**Southern
Water**

Our ref
PLAN-029570

Proposal: Detached dwelling - Resubmission of FP/201/18/PL.

Site: FP/185/19/PL: - Mermaid and Playbox, Sea Road, Felpham, PO22 7AW.

BLOCK PLAN

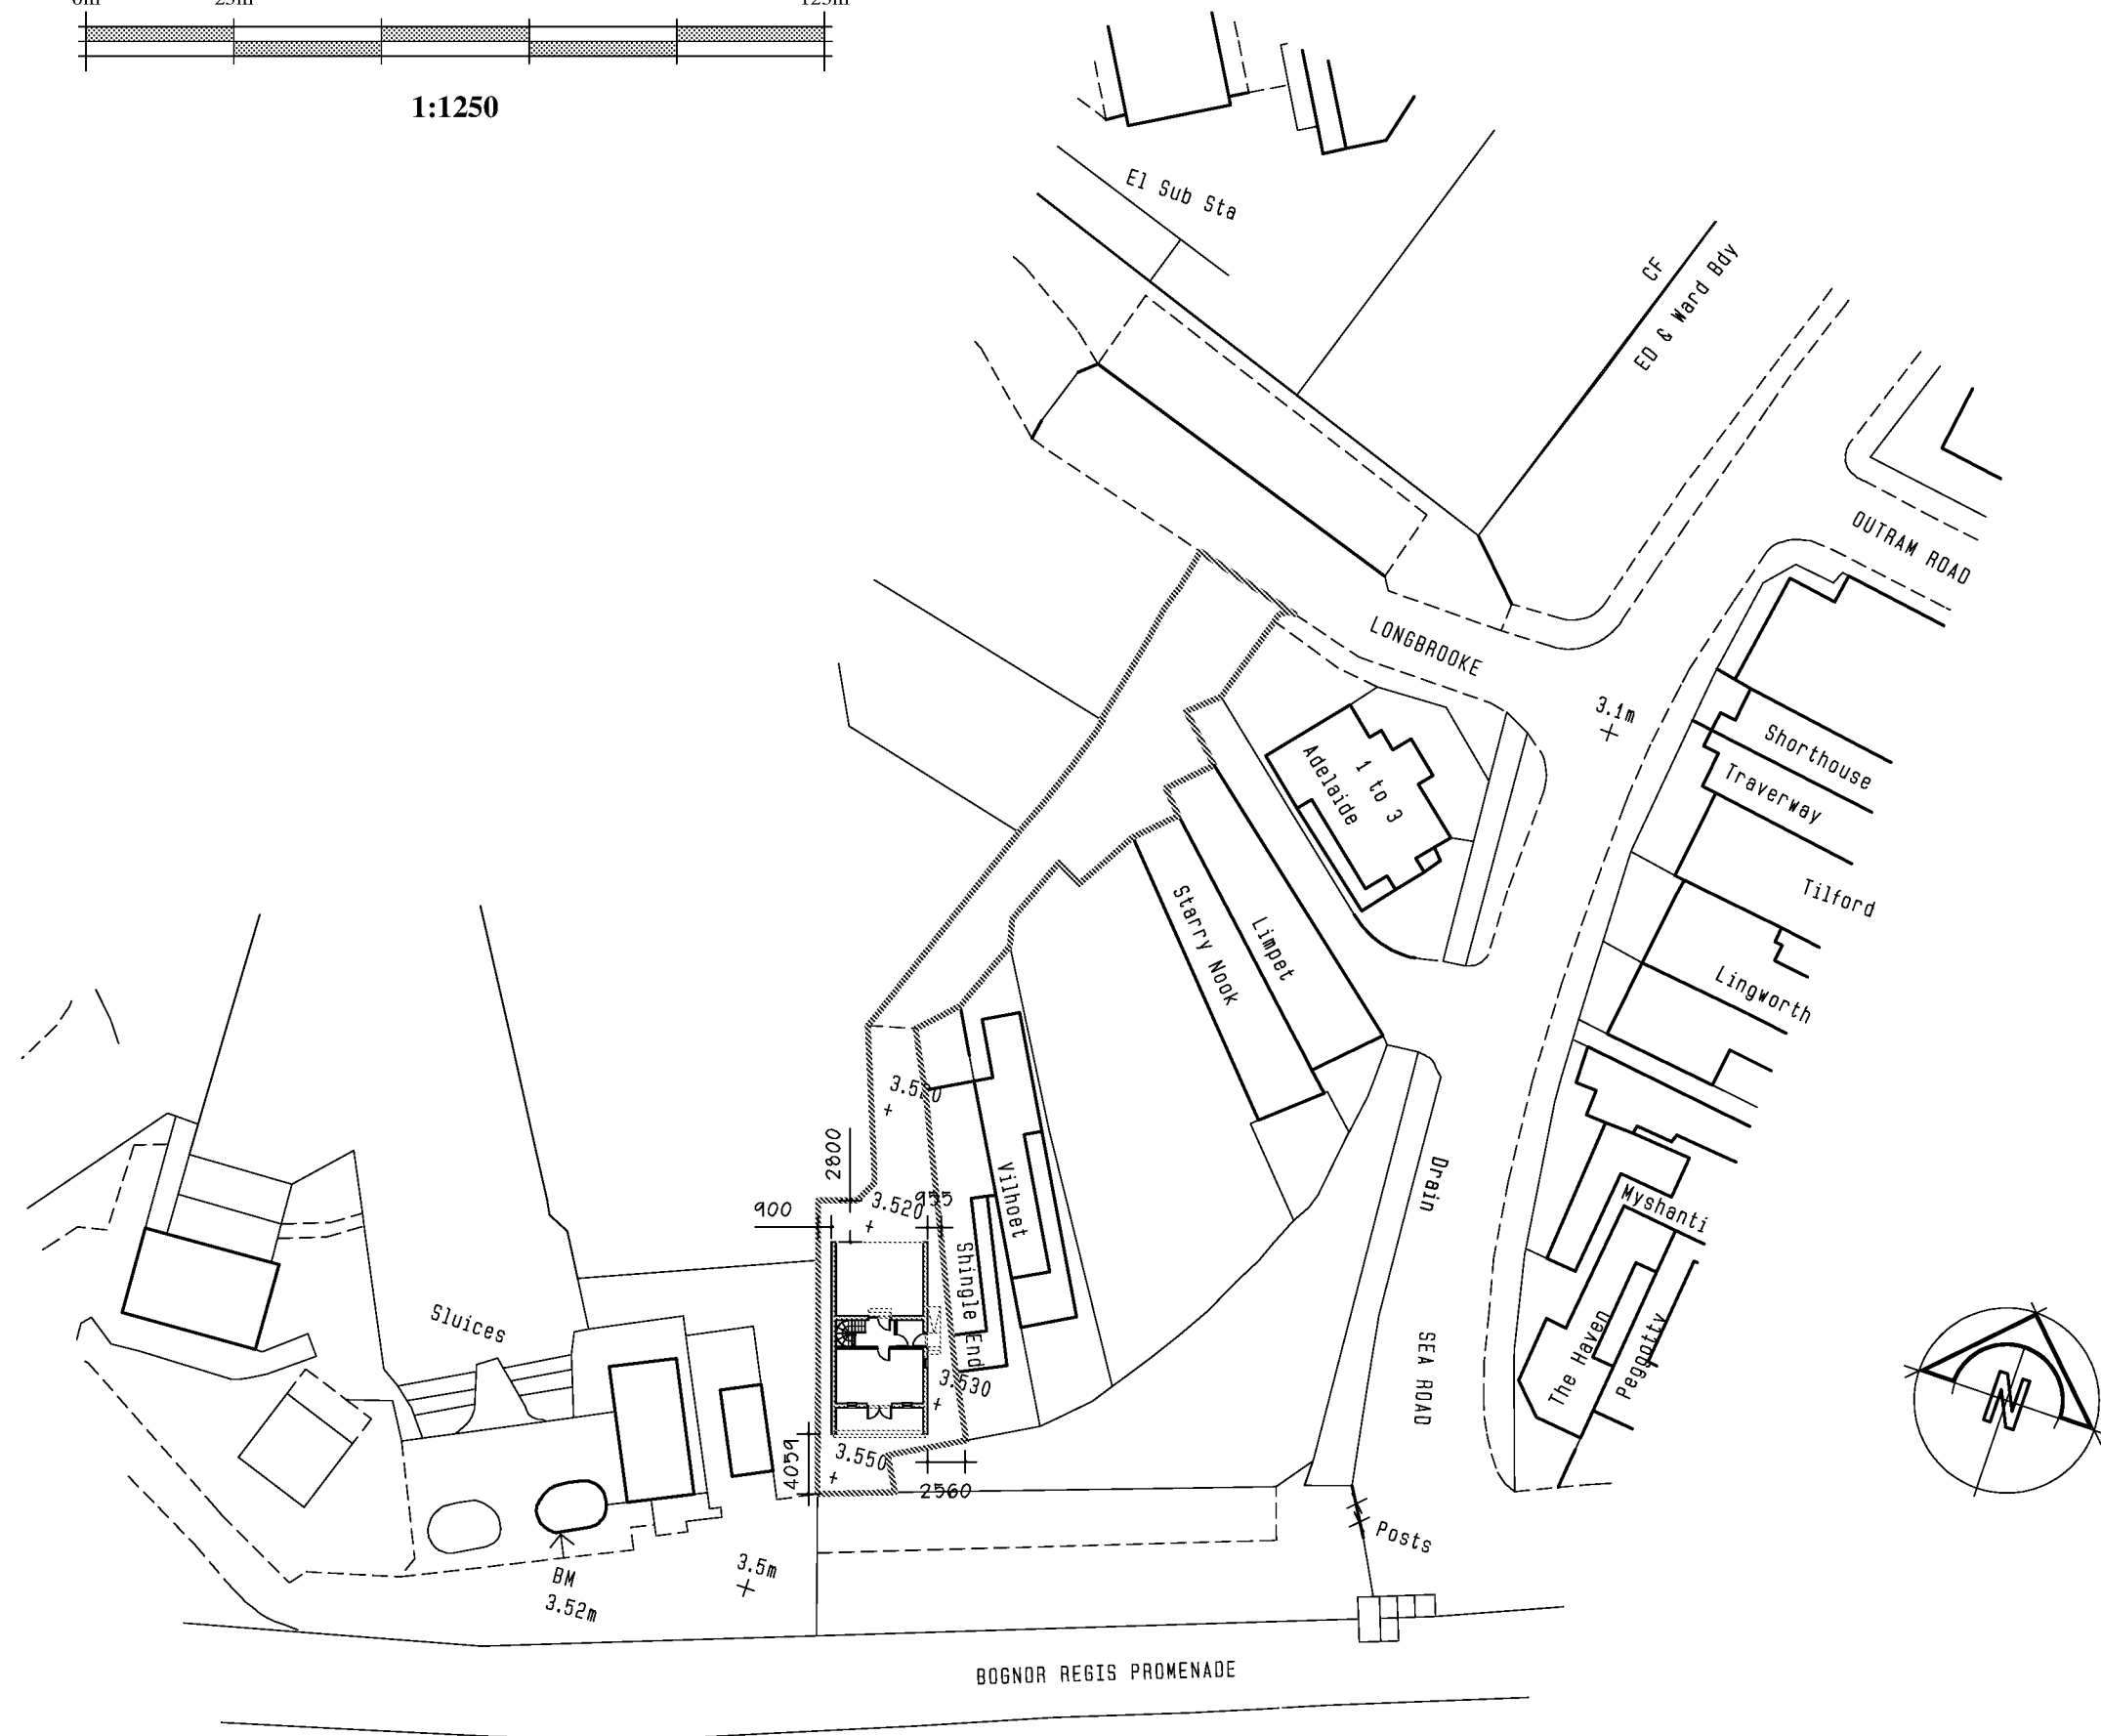
Please find attached a plan of the sewer records showing the approximate position of a public surface water sewer within the site. The exact position of the public sewers must be determined on site by the applicant before the layout of the proposed development is finalised.

- The 150 mm diameter surface water sewers require a clearance of 3 metres on either side of the gravity sewers to protect it from construction works and to allow for future access for maintenance.
- No development or tree planting should be carried out within 3 metres of the external edge of the public gravity sewer without consent from Southern Water.
- No soakaways, swales, ponds, watercourses or any other surface water retaining or conveying features should be located within 5 metres of a public sewers.
- All existing infrastructure should be protected during the course of construction works.
